## Development Facilitation Team (DFT) – Review Comments

Project No: PR-2024-010803 Date: 5/14/2025 Agenda Item: #12 Zone Atlas Page: L-20

Request: Subdivision and Vacation of Easement

Location: 301 Eubank Blvd between Acoma and Bell Ave SE containing 1.5 acres

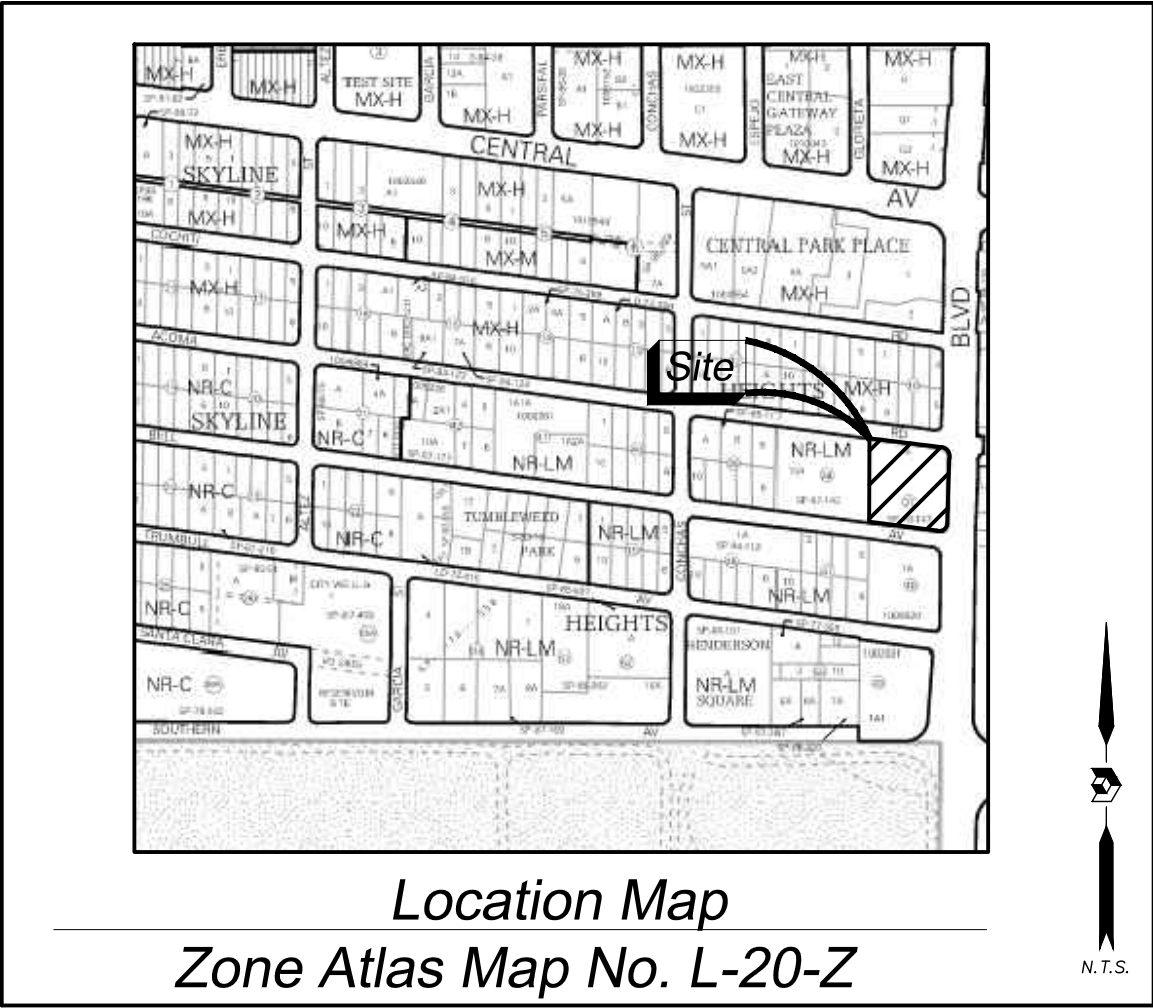
1. No objection to the proposed subdivision.
  - a. Please add the following note on the plat:
    - i. “Existing public water and/or sanitary sewer infrastructure may not be constructed or sized to adequately serve potential future development. Improvement or upsizing of existing public infrastructure may be required as a condition of future development approval.”
2. Informational comments:
  - a. For future development please place a Request for Availability online at the following link: [http://www.abcwua.org/Availability\\_Statements.aspx](http://www.abcwua.org/Availability_Statements.aspx). Requests shall include fire marshal requirements. An executed statement must be obtained prior to approval.
  - b. There is currently a bill size 3 (1-1/2” metered service point) that can potentially be utilized for one of the lots as well as any existing sanitary sewer service if adequate.

- Clarify how existing easements will be affected and if a vacation action or dedication of ROW will be needed.
- Formal submittals will require that all public notice requirements of IDO Section 6, Table 6-1-1 are completed prior to submitting the application, and included in the application file.
